WEST SUSSEX COUNTY COUNCIL CONSULTATION

TO:	Arun District Council FAO: Richard Castro-Parker
FROM:	Highways, WSCC
DATE:	21/09/2018
LOCATION:	1-7, Canada Road, Arundel, BN18 9HZ
SUBJECT:	AB/4/18/PL Demolition of 4 No. existing bungalows & erection of 5 No. 2 bedroom dwellings with associated parking & landscape.
DATE OF SITE VISIT:	n/a
RECOMMENDATION:	☒ Advice ☐ Objection ☐ Modification ☐ No Objection ☐ More Information ☐ Refusal
S106 CONTRIBUTION TOTAL:	n/a

Site Plan 1:200

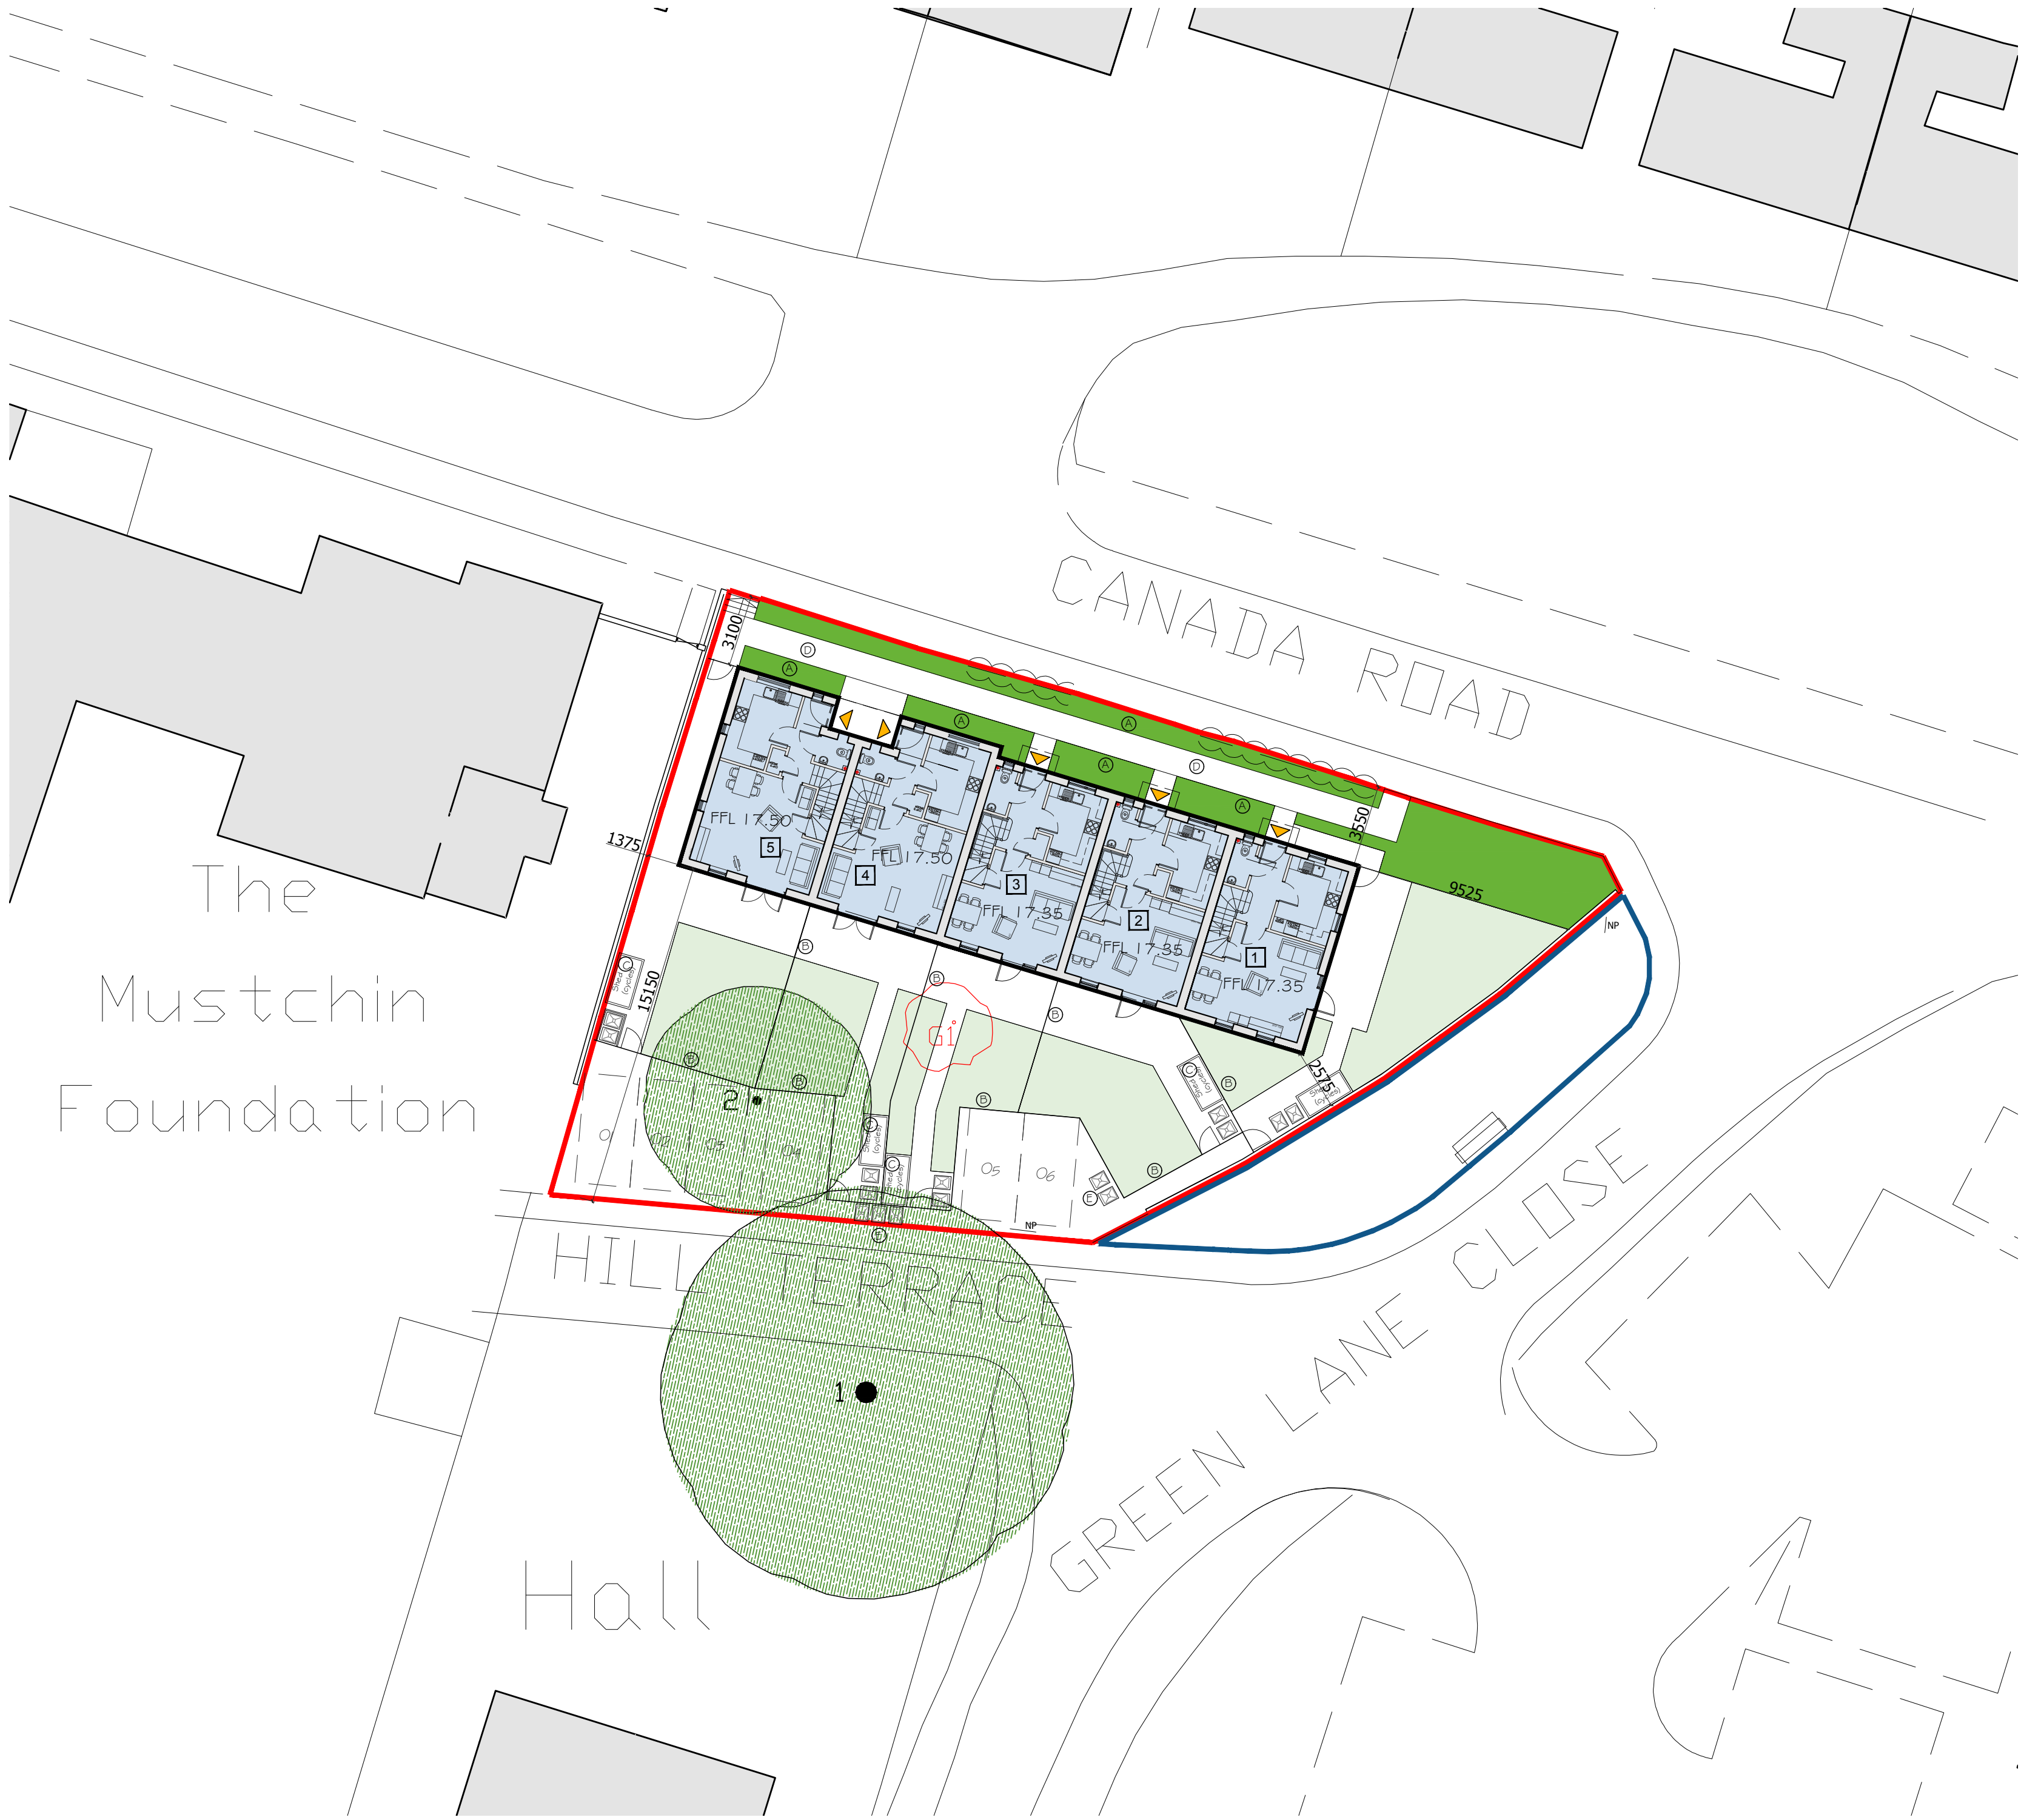
I note the site plan provided annotates areas 'owned' by WSCC. This is not strictly true as the areas indicated as considered 'adopted public highway' and not 'owned' by WSCC.

The layby arrangement will require works upon land consider public highway and without any 'Stopping Up' the spaces created could not be reserved for use specific use by residents of the proposed units. I note a slither at the southern extent of these spaces is not adopted highway. The footway realignment works to facilitate the creation of this layby are within private land. The highway works would therefore need to be implemented via a combined Section 38/278 Agreement.

The applicant should clarify if it is intended to have the areas of public highway within then layby 'Stopped Up'. Though on initial inspection I do not believe this will be satisfactory to the Local Highways Authority.

The Local Highways Authority does not consider that the proposal would have a 'severe' impact on the operation of the maintained highway network. Nevertheless the applicant should consider the limitations/implications of providing a parking provision within the adopted highway. It would be advised that the applicant clarify their intentions with regard to the layby and legal status of this land after implementation.
